I am writing as a parent of a child that attends Darlington Public School regarding the proposed development by the University of Sydney, MP 07_0158 – Abercrombie Street Precinct, Syd Uni. Darlington Public School is an inner city school servicing the suburbs of Chippendale, Darlington and parts of Redfern. The school is directly adjacent to the western border of the project.

STAGE 1 PLAN

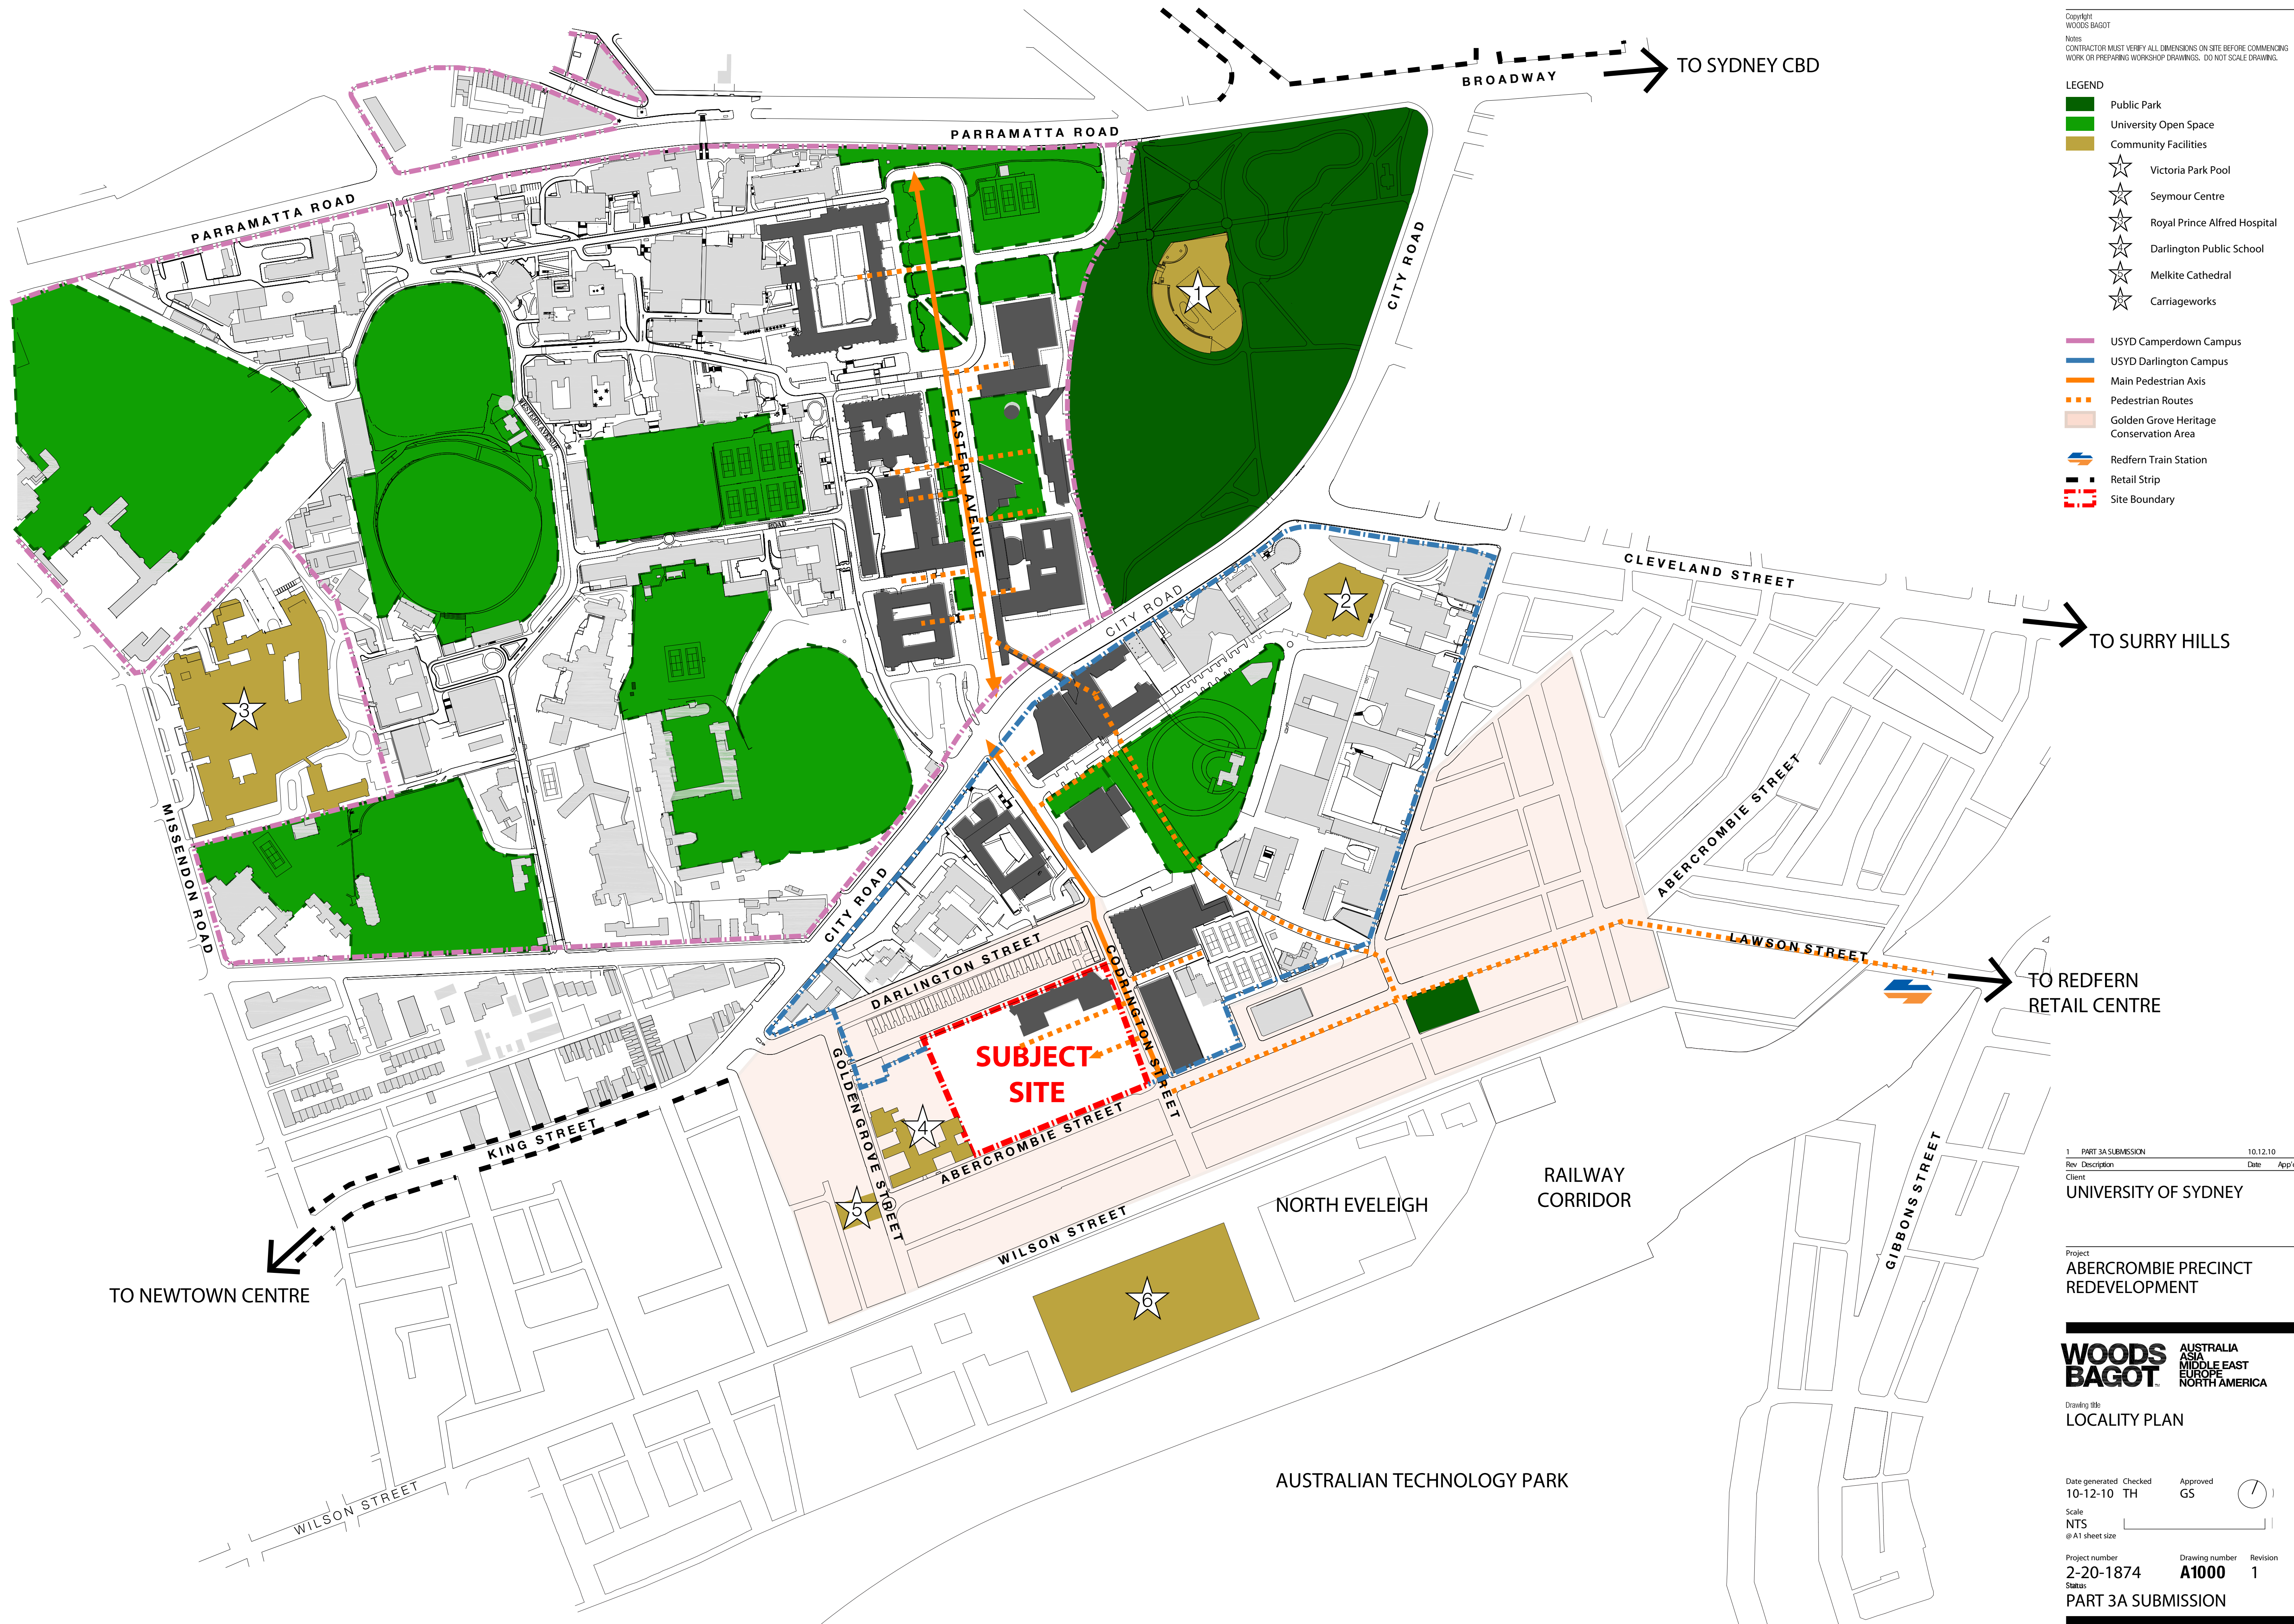
The proposed access point for the site is on Abercrombie Street and is directly adjacent to the school classrooms on their North East border of the school site. Locating the access point for trucks would:

- produce unacceptable levels of noise and vibration in the school classrooms that border that entrance – year 2, 4, 6 and both kindergarten classes. This is also particularly significant for the 2 kindergarten classrooms which face the development to the north with only glass panels and glass doors on that side.
- create an unsafe corridor for school children and parents that walk, or ride to school along Abercrombie Street (north side). This includes many unaccompanied but young children entering and leaving the school.
- create an unsafe car drop off and pick up point on Abercrombie Street (the main drop off point at the school).
- reduce the drop off and pick up point area for numerous children who are transported by car.

Proposing an entry point in Abercrombie Street will force trucks and plant to be transported through residential and school areas to the project site. The more direct route is from City Road to Codrington Street and will allow access directly into the project site without passing through residential areas or the proposed access that is within metres of classrooms, or across the footpaths and pedestrian crossing that children use to access the school.

As per the current development plan, the proposal calls for an underground car park to be built for the student accommodation and University staff. The car park will accommodate 185 car spots, and its entrance will be on Abercrombie Street, at approximately the same point of the construction access.

The concerns raised above about the access point to the construction site are the same for this car park access point increasing the risk to school children's safety, in an area that has already been highlighted through the respective organisations (Council, Police, and RTA). The increased traffic flows and access point are an unacceptable risk to the children who attend the school. There is no justification for this level of risk to a school community, particularly as the University has another street frontage without school or residential issues (the University being the only stakeholder for Codrington Street) and an access street internal to project (Darlington Lane).
